**20 Fairhaven Road, Caversfield, Bicester, OX27  
8TX**

**21/01806/F**

**Proposal:** Garage conversion

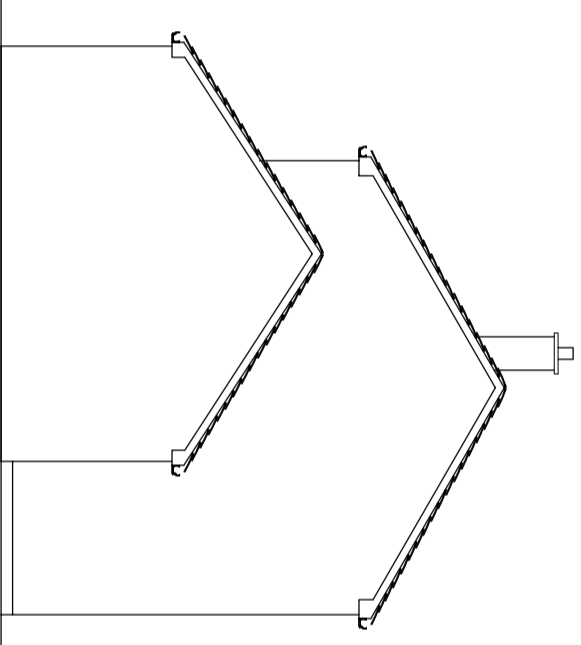
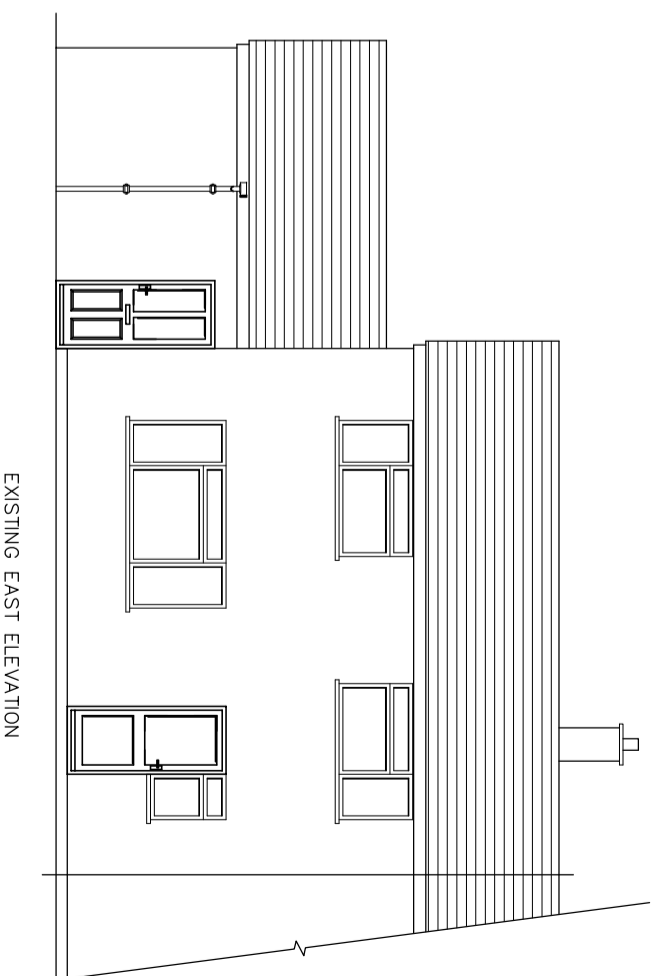
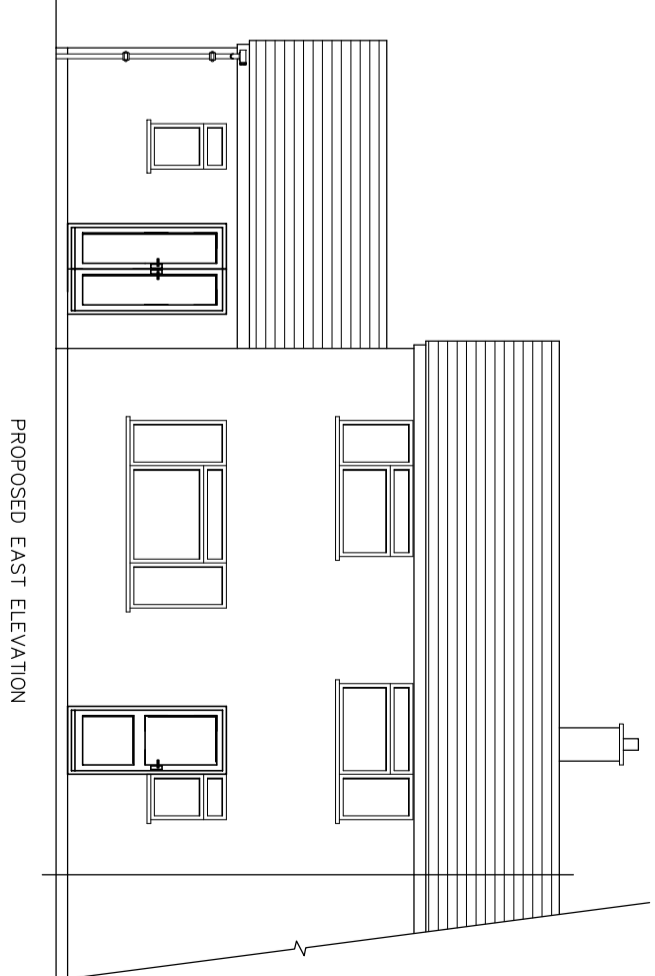
The proposals would be visible within the public realm of Fairhaven Road. The applicant has confirmed that materials used to fill the existing garage door opening and for the new fenestration would match the existing.

The scale of the window fronting Fairhaven Road is on the large side when compared with the existing fenestration, however when viewed within the streetscene the scale is in-keeping with other ground floor windows.

Conclusion: on balance, the proposed change in fenestration is considered acceptable.
